CITY OF ALBUQUERQUE

Re: Take 5 Oil Change
1125 Snow Vista Blvd. SW
Traffic Circulation Layout
Engineer's Stamp 09-19-23 (M09-D021C)

Based upon the information provided in your submittal received 10-19-23, the above referenced plan cannot be approved for Building Permit until the following comments are addressed:

Job Number  
**23007**  
Sheet  
**C2.0**

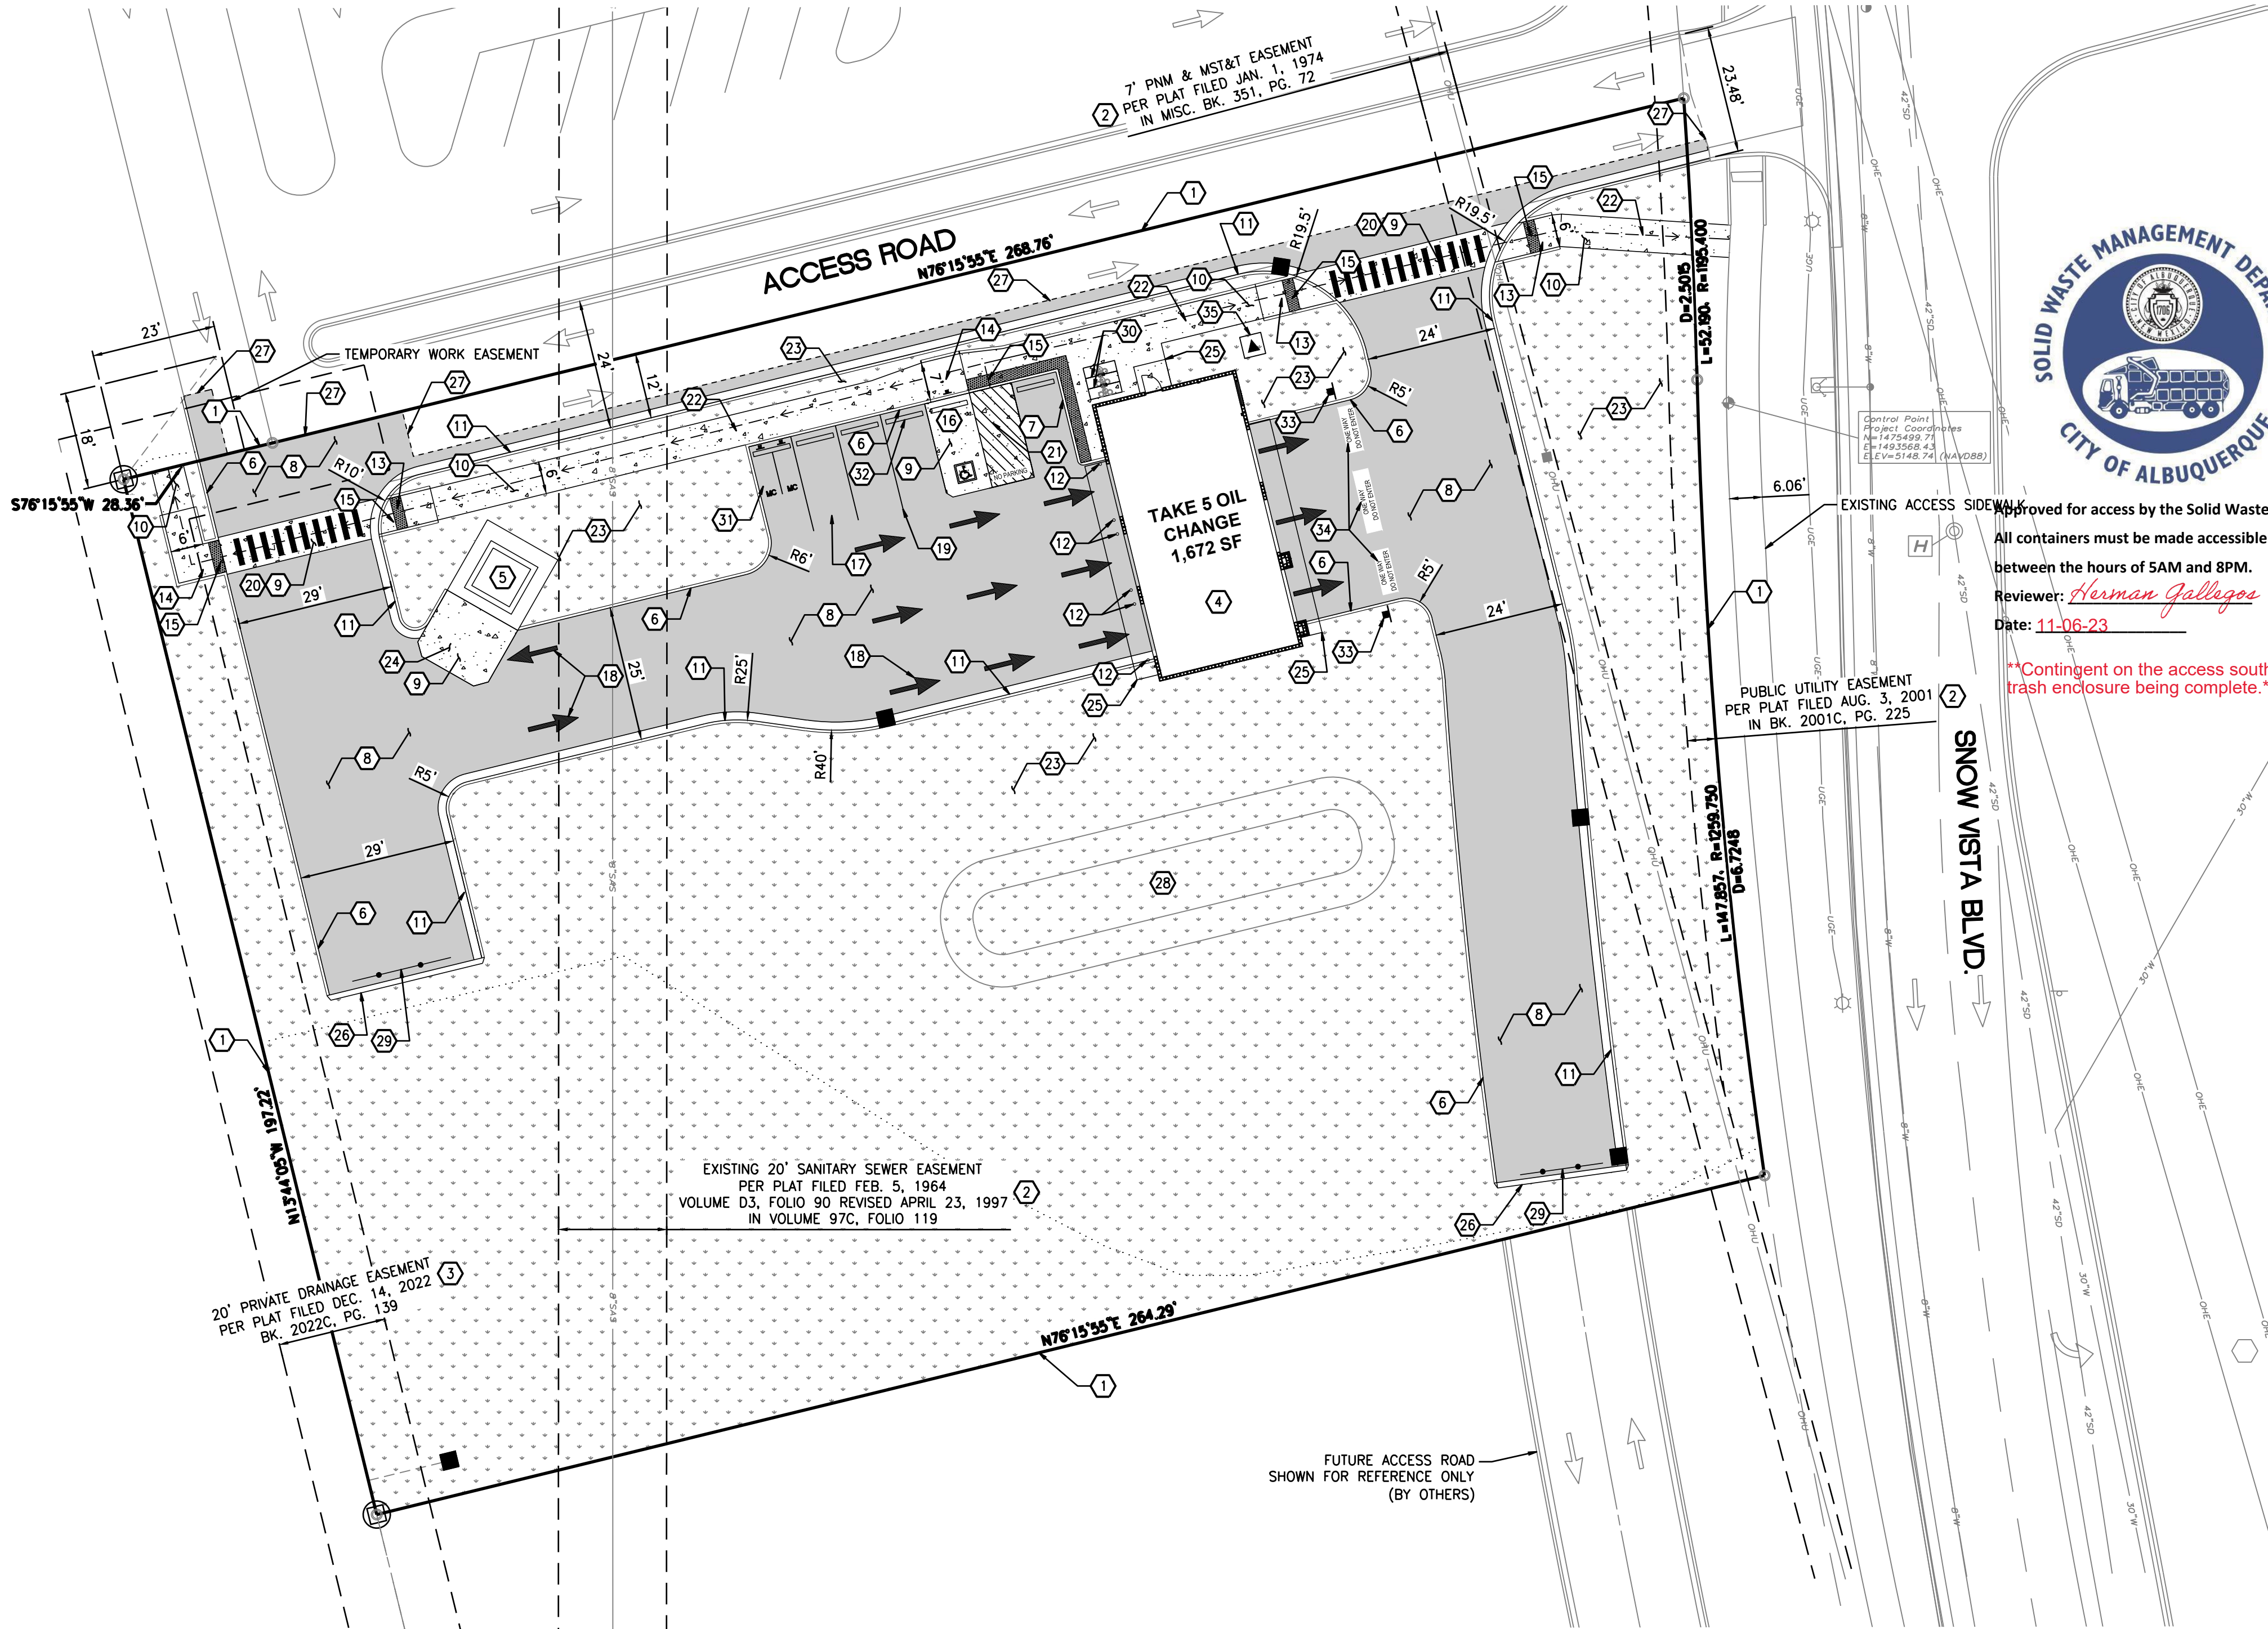
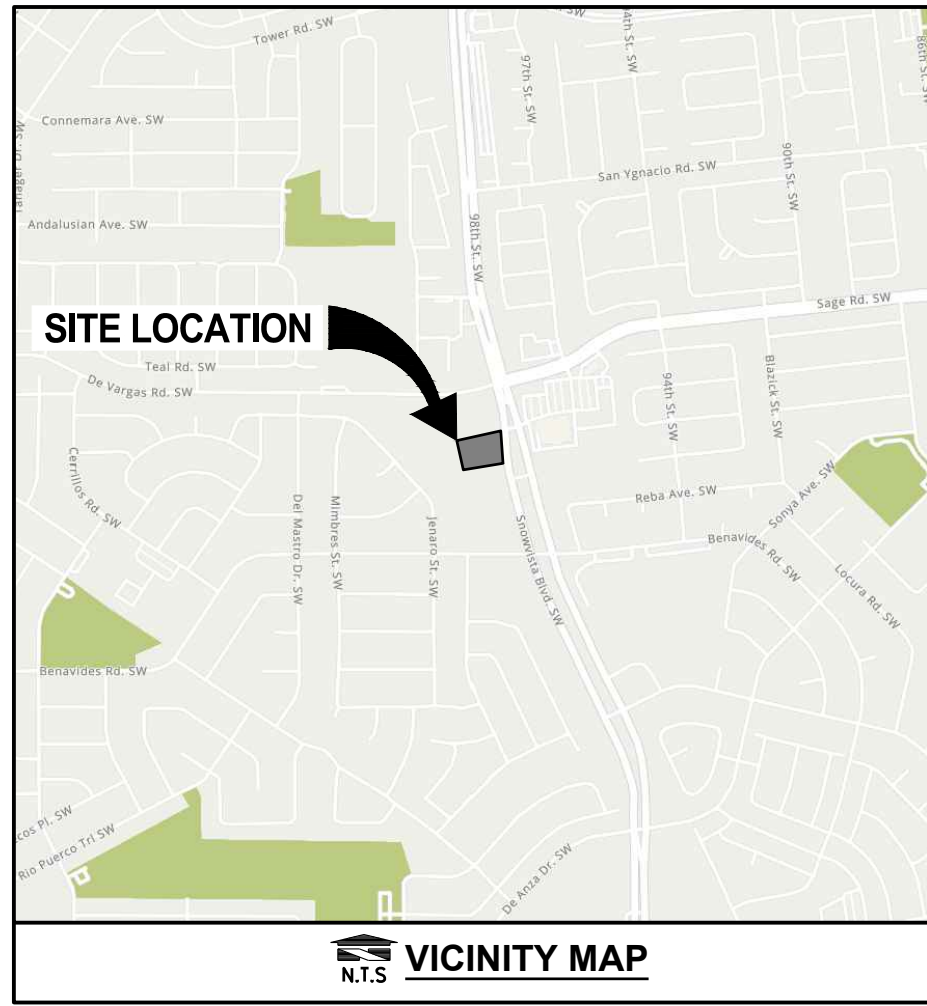
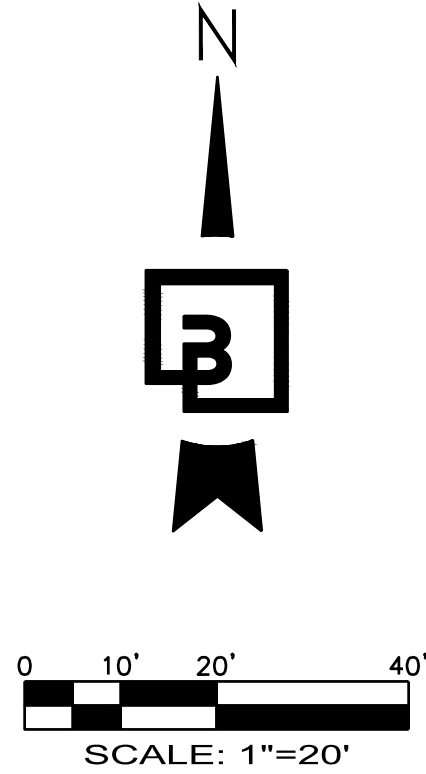
1. Please show a vicinity map and the parking calculations table on the site plan sheet C2.0.
2. Provide approved plat showing the shared accesses agreement.
3. List the number of Motorcycle and Bicycle parking spaces required by the IDO.
4. Please show on the site plan the existing site access and sidewalk width.
5. Show all drive aisle widths and radii. Some dimensions are not shown.
6. The minimum drive aisle dimensions are shown below

Minimum Drive Aisle Width
Two Way Traffic	22'
Main Circulation Road	24'
Fire Lane	20'

7. The ADA parking space and pathway appear to be drawn differently on the details sheet. Please address this concern.

8. Please show Transportation details on one sheet.
9. The ADA accessible parking sign must have the required language per 66-7-352.4C NMSA 1978 **"Violators Are Subject to a Fine and/or Towing."** Please call out detail and location of signs.

10. Motorcycle parking spaces shall be designated by its own conspicuously posted upright sign, either free-standing or wall mounted per the zoning code.

11. The pavement marking "MC" should be shown in the opposite direction for motorcycles entering the parking space.
12. All bicycle racks shall be designed according to the following guidelines:

13. Bicycle racks shall be sturdy and anchored to a concrete pad.
14. A 1-foot clear zone around the bicycle parking stall shall be provided.
15. Bicycle parking spaces shall be at least 6 feet long and 2 feet wide.

16. List radii for all curves shown; for passenger vehicles. Radius for delivery trucks, fire trucks, etc. is 25 ft. or larger.
17. Per the IDO, a 6 ft. wide ADA accessible pedestrian pathway is required from the public sidewalk to the building entrances. Please clearly show this pathway and provide details.

18. Per DPM, a 6 ft. wide ADA accessible pedestrian pathway is required from the ADA parking stall access aisles to the building entrances. Please clearly show this pathway and provide details.

19. Refuse vehicle maneuvering shall be contained on-site. The refuse vehicle shall not back into the public right of way.; provide a copy of refuse approval.

20. Please provide a copy of Fire Marshal approval.
21. All one-way drives shall have "One Way" and "Do Not Enter" signage and pavement markings. Please show detail and location of posted signs and striping.

22. Show the Intersection clear sight triangle and add the following note to the plan: "Landscaping and signage will not interfere with clear sight requirements. Therefore, signs, walls, trees, and shrubbery between 3 and 8 feet tall (as measured from the gutter pan) will not be acceptable in the clear sight triangle.
